CITY OF ALBUQUERQUE

August 14, 2013

Re: Boulders Phase III (B10/D001D)
Drainage Report, Engineer's Stamp Date: 7/17/2013
Grading and Drainage Plan, Engineer's Stamp Date: 7/18/2013

ENGINEER'S SEAL	THE BOULDERS PHASE 3 GRADING AND DRAINAGE PLAN	DRAWN BY DY
			DATE 2-12-14
			DRAWING GRADING-PH 3
			SHEET # 1
			JOB # 2011005
VINCENT P. CARRICA P.E. #16212		TIERRA WEST, LLC 5571 MIDWAY PARK PLACE NE ALBUQUERQUE, NM 87109 (505) 858-3100 tierrawestllc.com

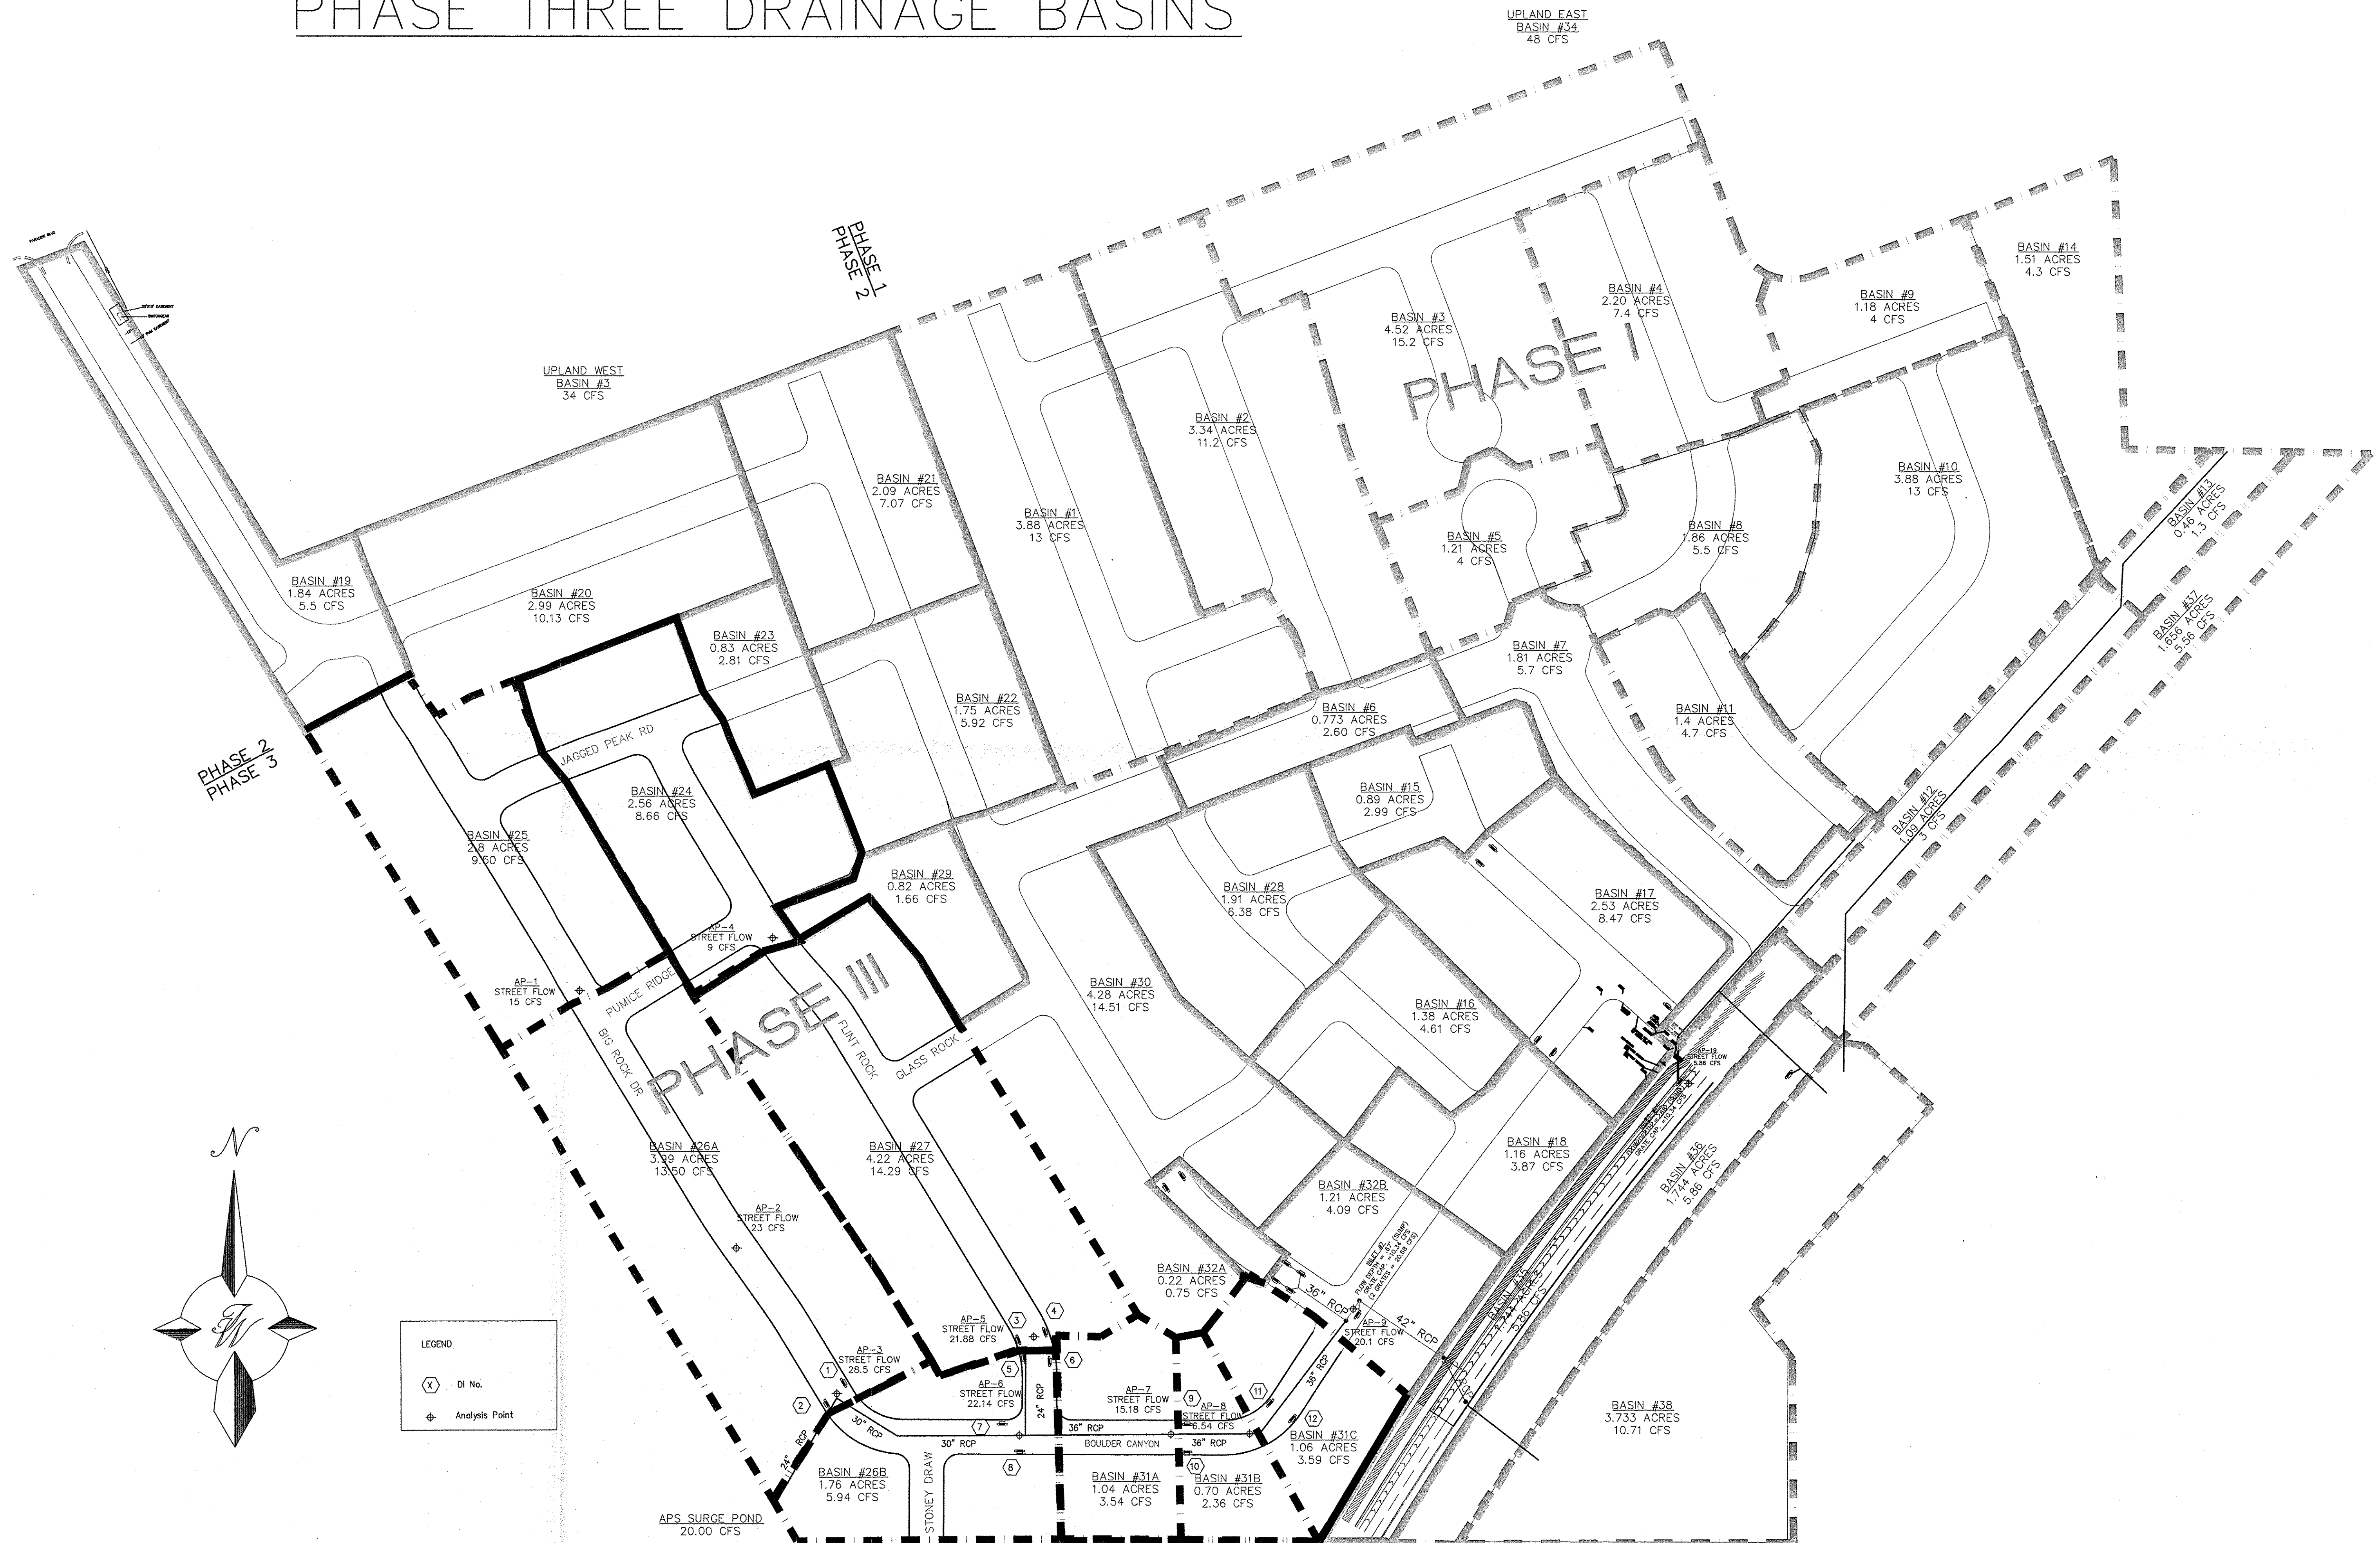
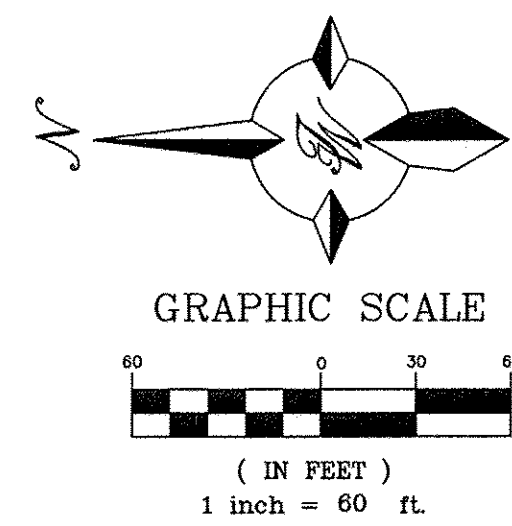
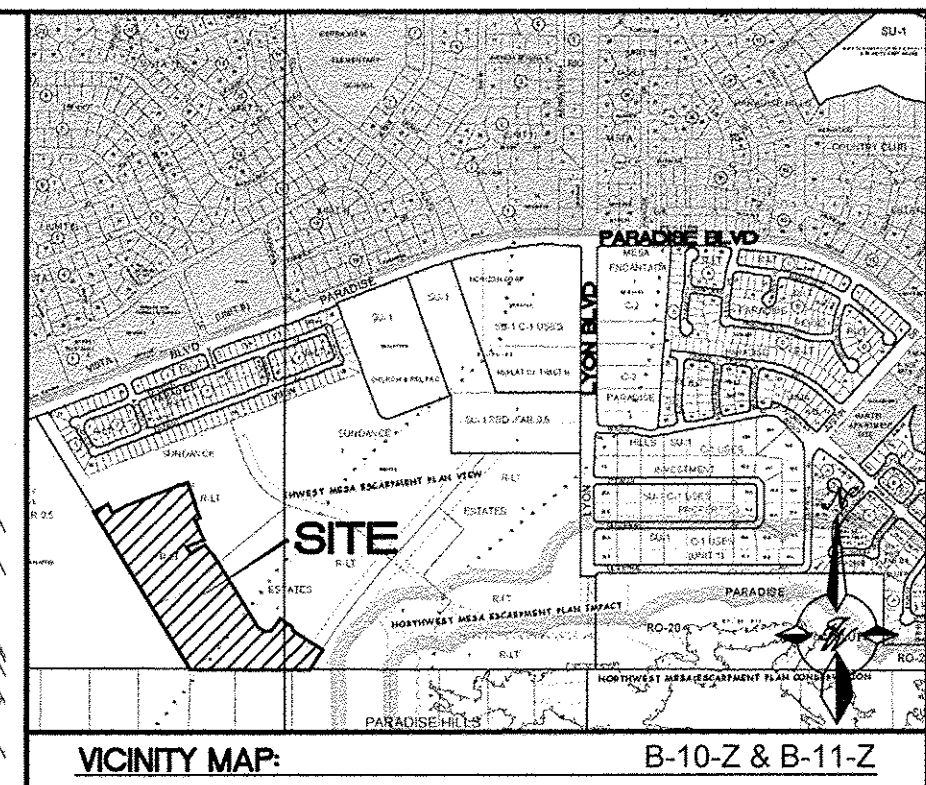
- Modify the vicinity map so it would show the limits of Phase III only.
- Include the street names and label Tract A and B. Clearly show the limits of Phase III.

- Show the existing contours as dashed and possibly at a lighter color for better clarification between existing and proposed contours.
- Include top and bottom elevations for the proposed retaining walls. If adjacent grade to the right-of-way is lower, the retaining wall should be included on the infrastructure list.

- Will there be a future connection to the south on Stony Draw Rd. There appears to be a 2' elevation difference between existing and proposed grade at the west end of the road.

- Increase the text sizes for the proposed spot elevations. Clearly show the existing and proposed spot elevations.
- Will there be barricades at the north end of Big Rock Dr.?

- Some lots drain to the back. Area there proposed retention ponds? Roof drain for these lots should drain to the front.
- Will there be any easement required for the construction of the 24" pipe across the APS site? Show existing and proposed drainage easements. Clearly show all the pipes that connect or will connect to the existing storm drain manhole within APS site.

- Please check the flow depth within Tract B in case the APS pond does overflow. Erosion protection On Tract B and floodwalls along lots 23 and 24 will be required. Include these improvements on the infrastructure list. Provide detail analysis for the emergency overflow as the flow enters Tract B. A driveway will be required for accessing the storm drain pipes.

- Provide inlet and storm drain pipe capacity calculations.
- Perform street capacity calculations for Big Rock Dr. by lots 23, 24, and 25. Double check the EGL at these locations to assure runoff does not enter these lots as it turns to the west. We recommend placement of inlet(s) north of lot 24. Also provide street capacity calculation other locations as necessary for the purposes of the inlet capacity calculations.

- Add the proposed storm drain pipe on Flint Rock to the infrastructure list.
- Are there any mountable curbs being proposed? Clearly show the usage of different curbing for this project.

ENGINEER'S SEAL	THE BOULDERS PHASE 3	DRAWN BY DY
		TRACT 6A GRADING AND DRAINAGE PLAN	DATE 1-27-14
		TERRA WEST, LLC 5571 MIDWAY PARK PLACE NE ALBUQUERQUE, NM 87109 (505)858-3100 tierreastllc.com	Offsite-Pond
	VINCENT P. CARRICA P.E. #16212		SHEET # 3 JOB # 2011005

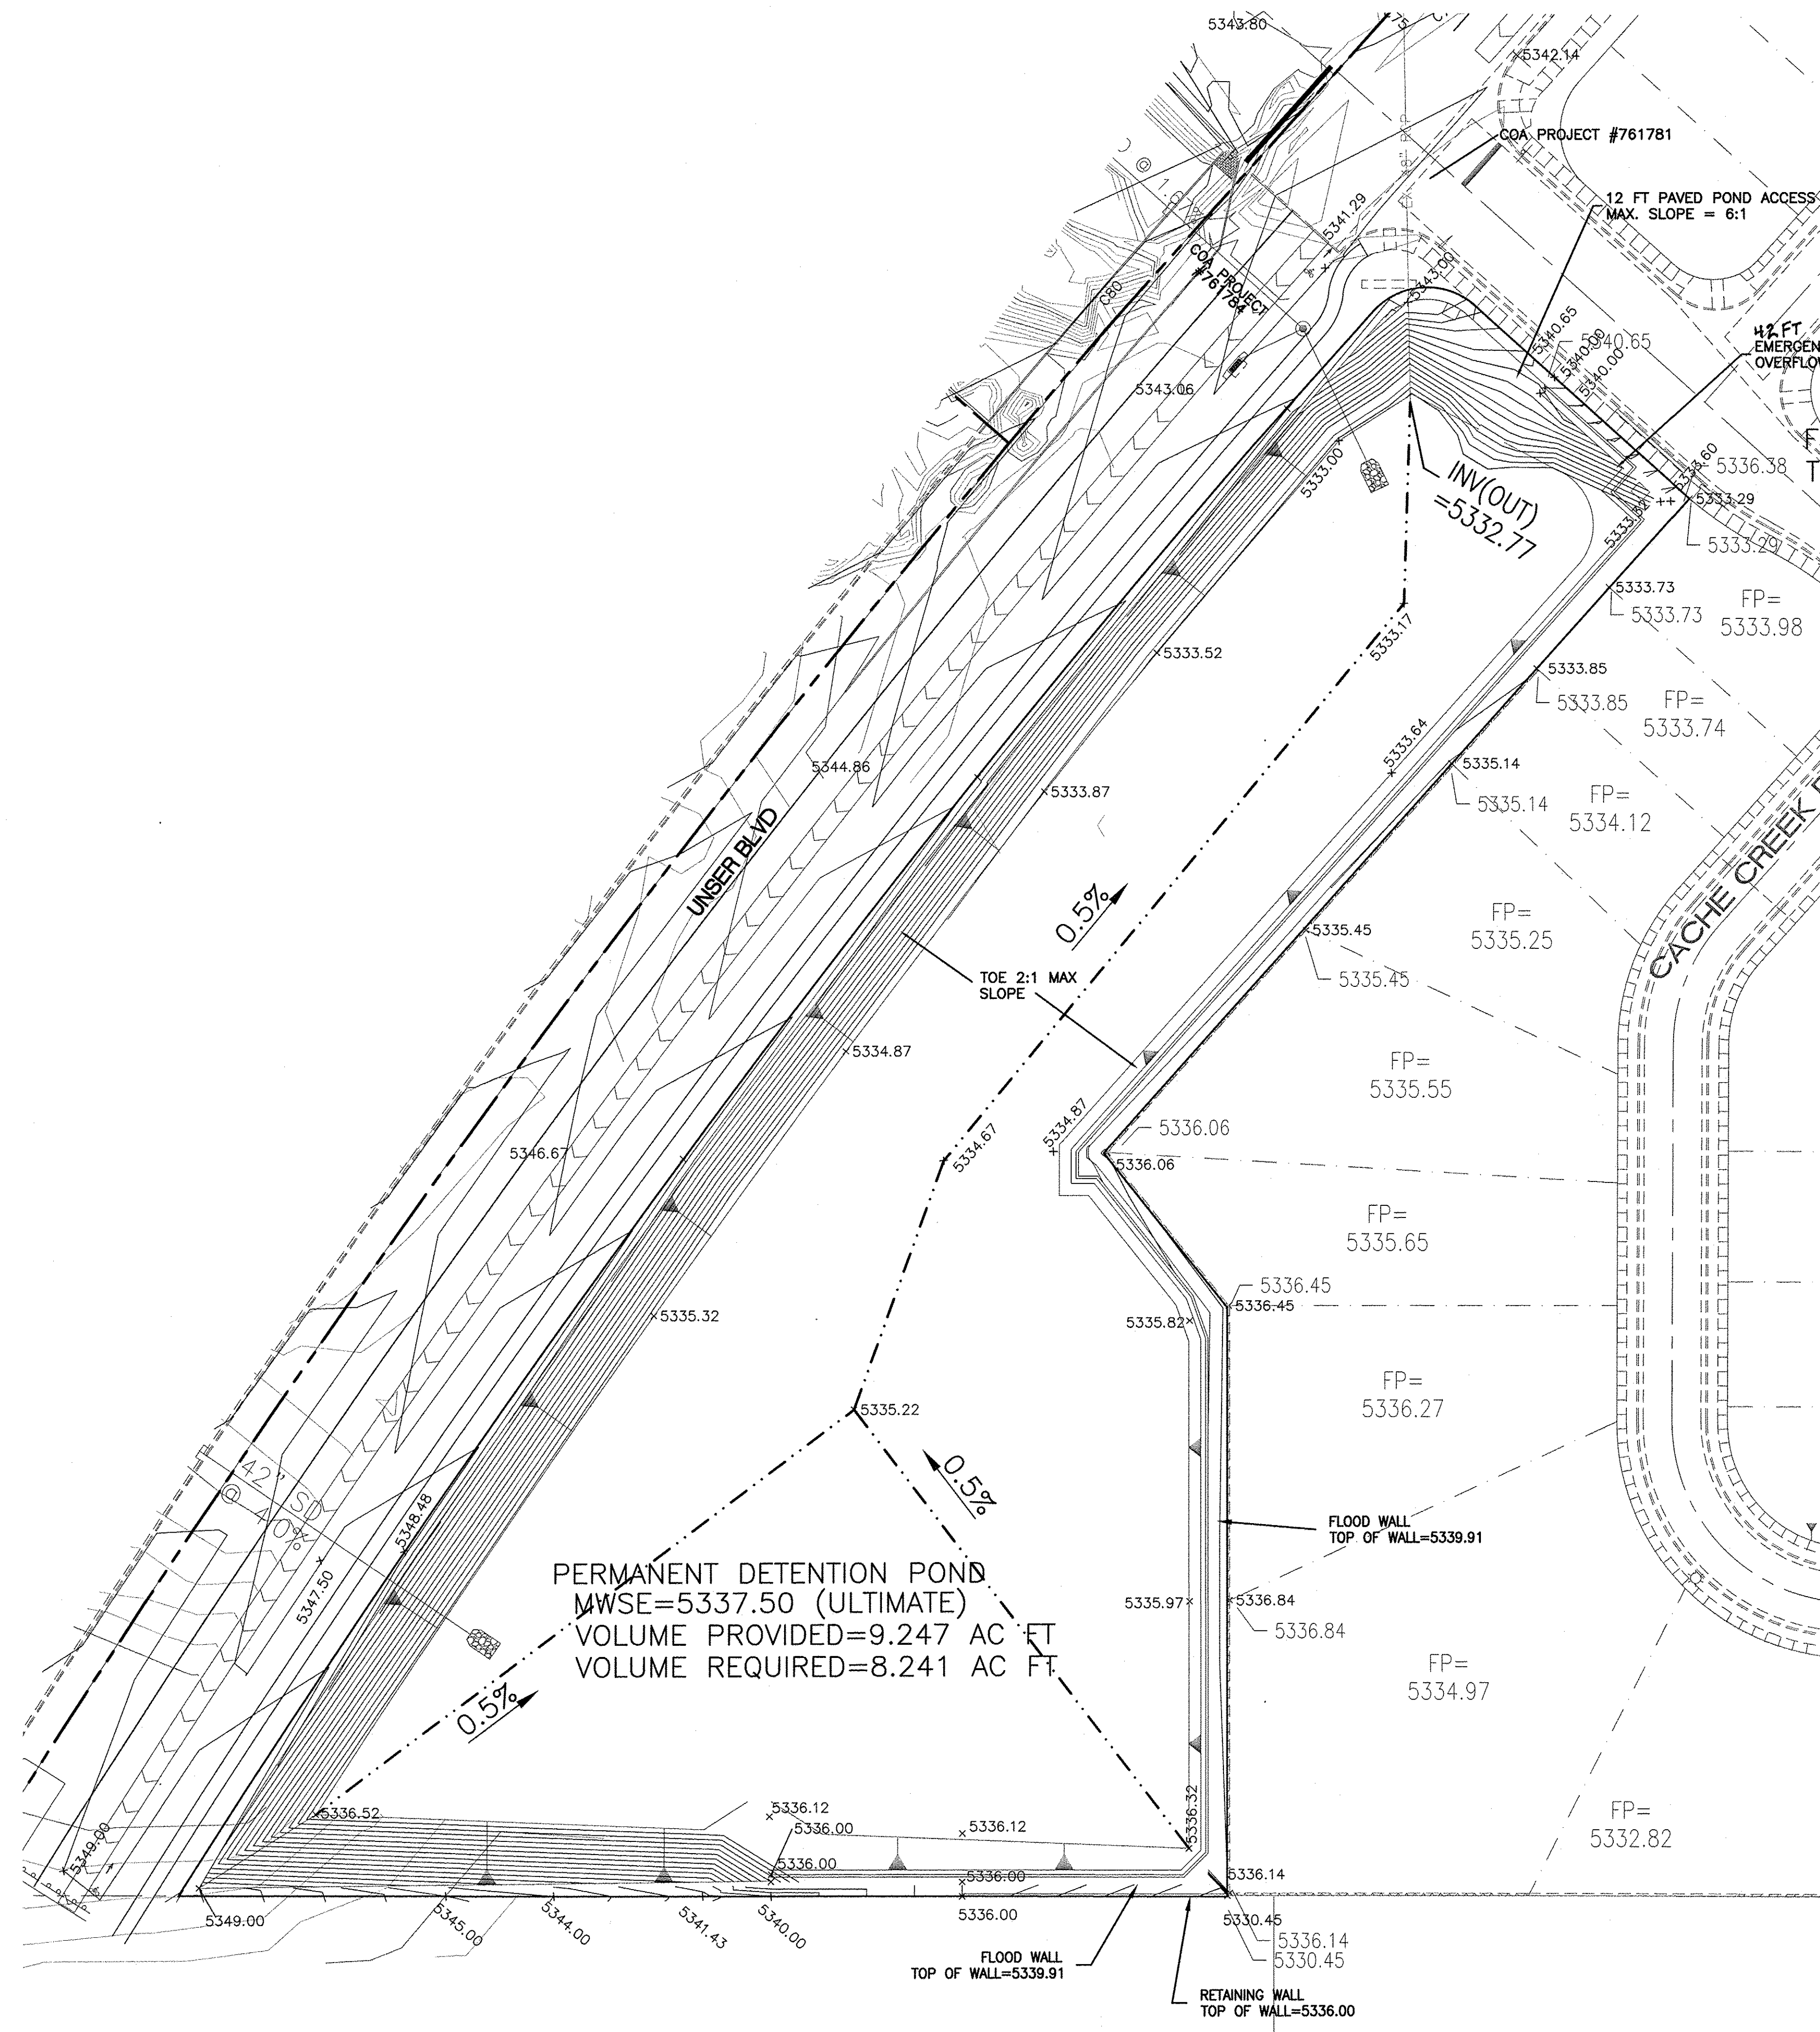
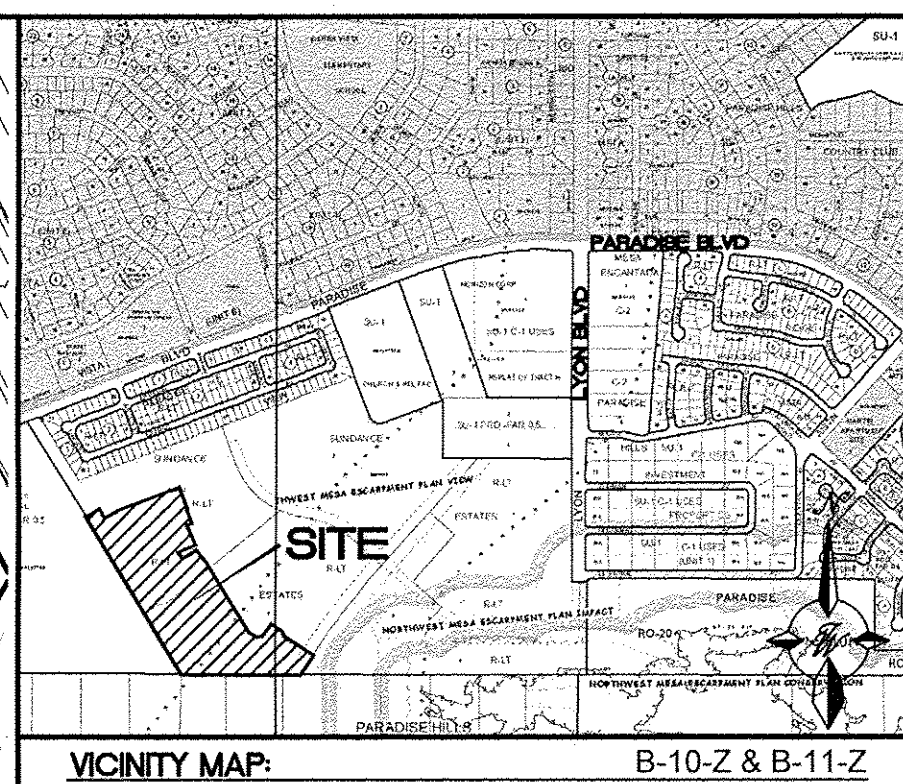
- Detention pond within Tract 6-A is shown to be 8.3 ac-ft on the infrastructure list. The existing volume for this pond is over 11 ac-ft. An approved grading plan is required for the changes to the pond.
